**Environment,
Climate Change
& Water**

Your reference: 9040292
Our reference: DOC11/55327

**RE: NSW Department of Planning and Infrastructure - Proposed Modification to Chester Hill
Materials Recycling Facility (DA 06_0052 MOD 2) – Bankstown Local Government Area**

Figure 2 – Approved Site Layout (as modified)

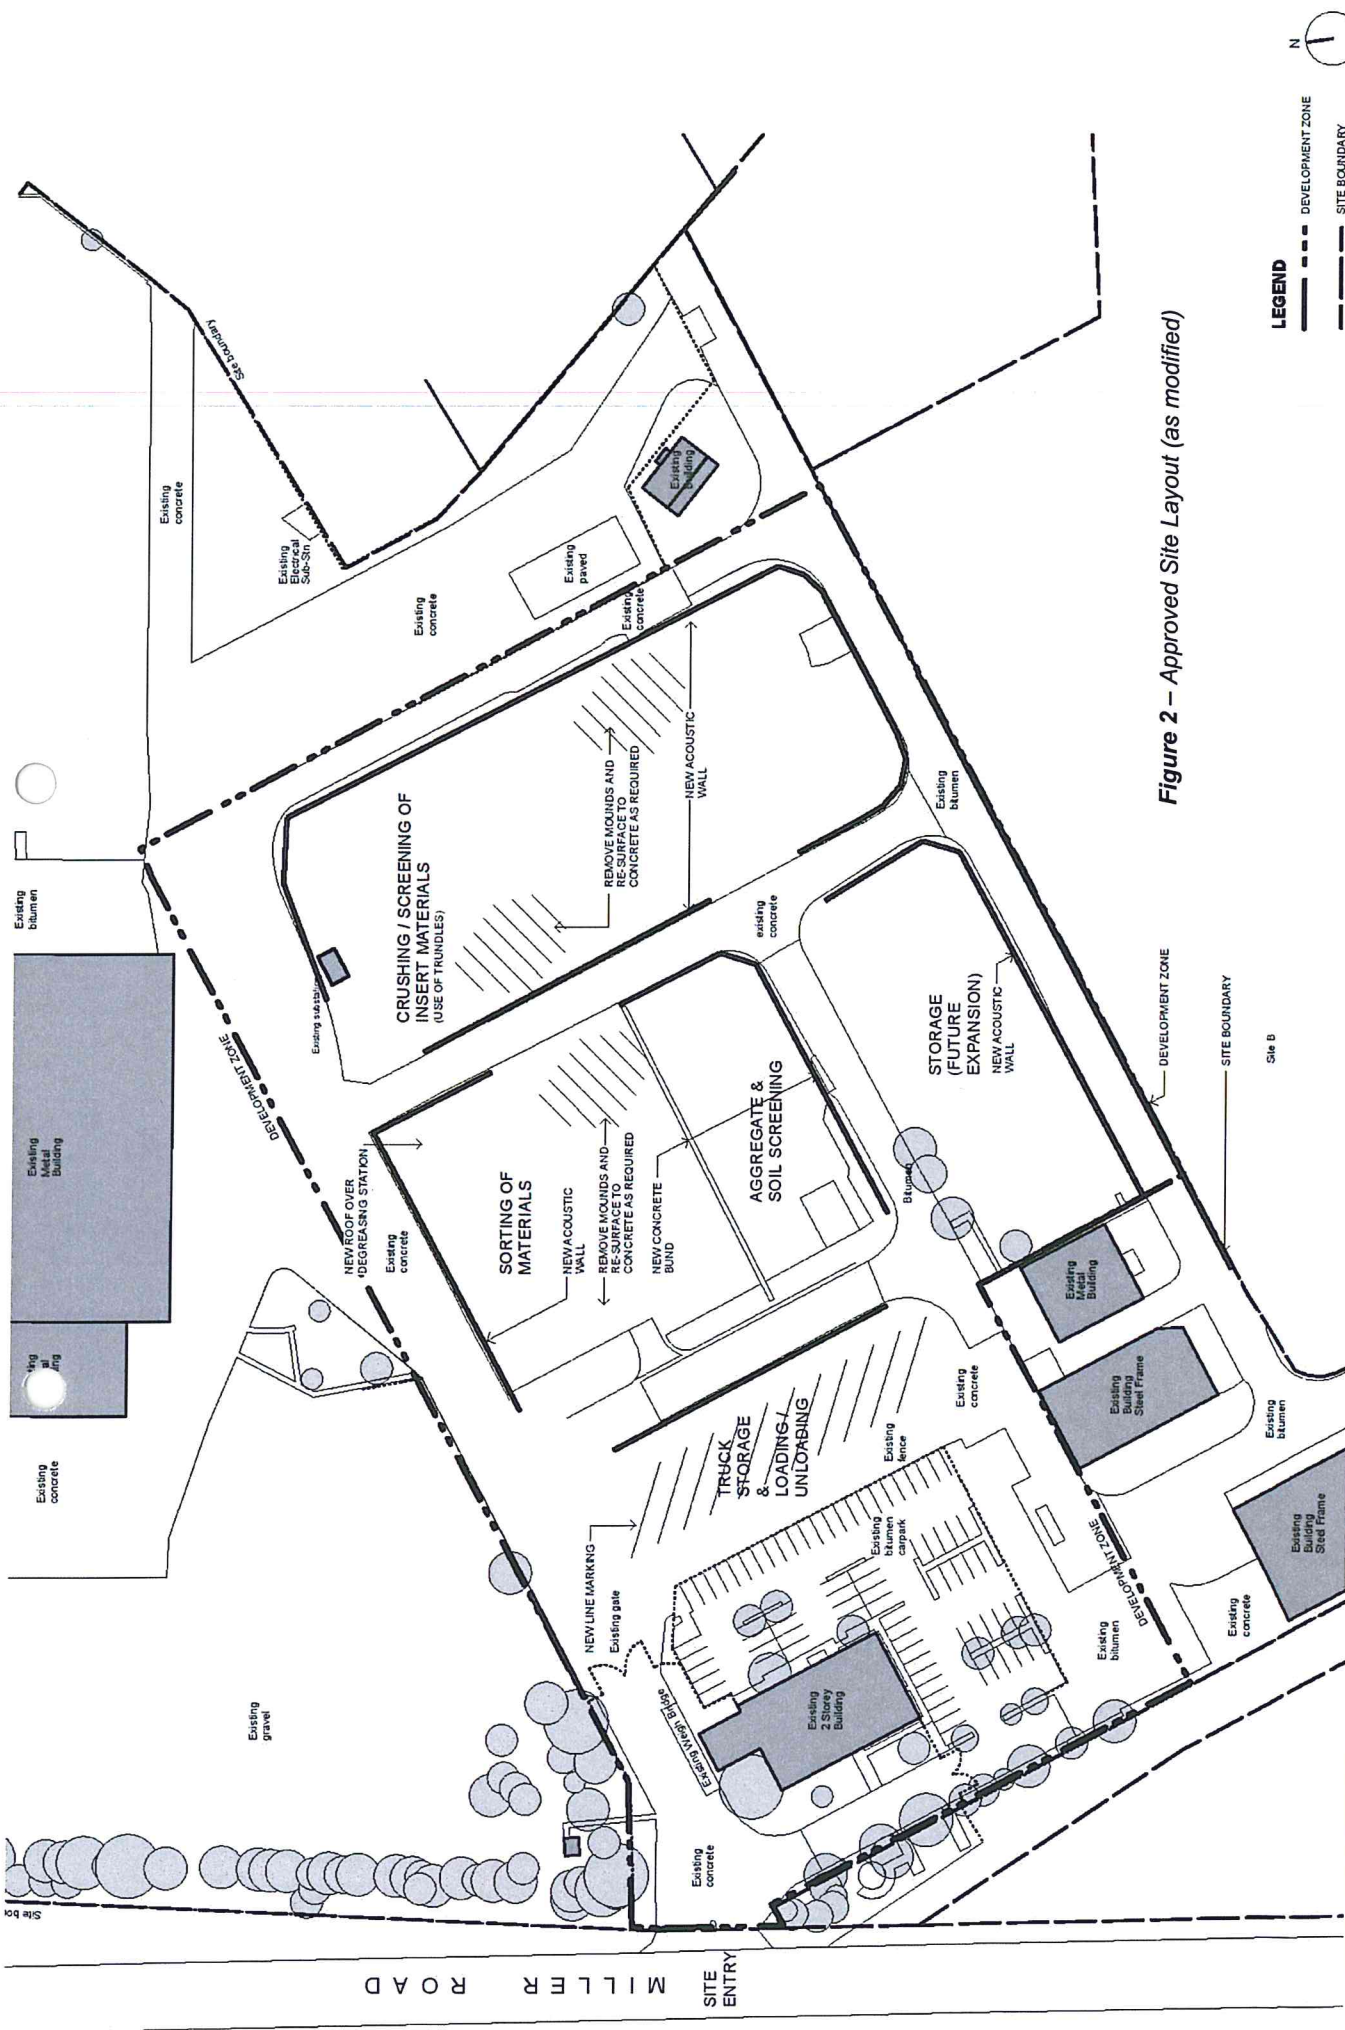
4. The EPA notes that Figure 2 in the "Environmental Assessment Report for Modification of the Chester Hill Materials Recycling Facility (06-0053 Mod1) To Include the Recycling of Additional Types of Material" outlines a system of acoustic barriers to be installed across the Premises. The current proposal to keep the shipping containers presently onsite as noise barriers does not state if the internal acoustic barriers (detailed in Figure 2 of the previous modification) are to be replaced by shipping containers or deleted from the consent entirely.

It should also be noted that the acoustic barriers outlined in Figure 2 of the previous modification would separate the various activities undertaken onsite. The proposed modification does not provide any information on how this separation of activities will be achieved if the acoustic barriers are not installed or removed.
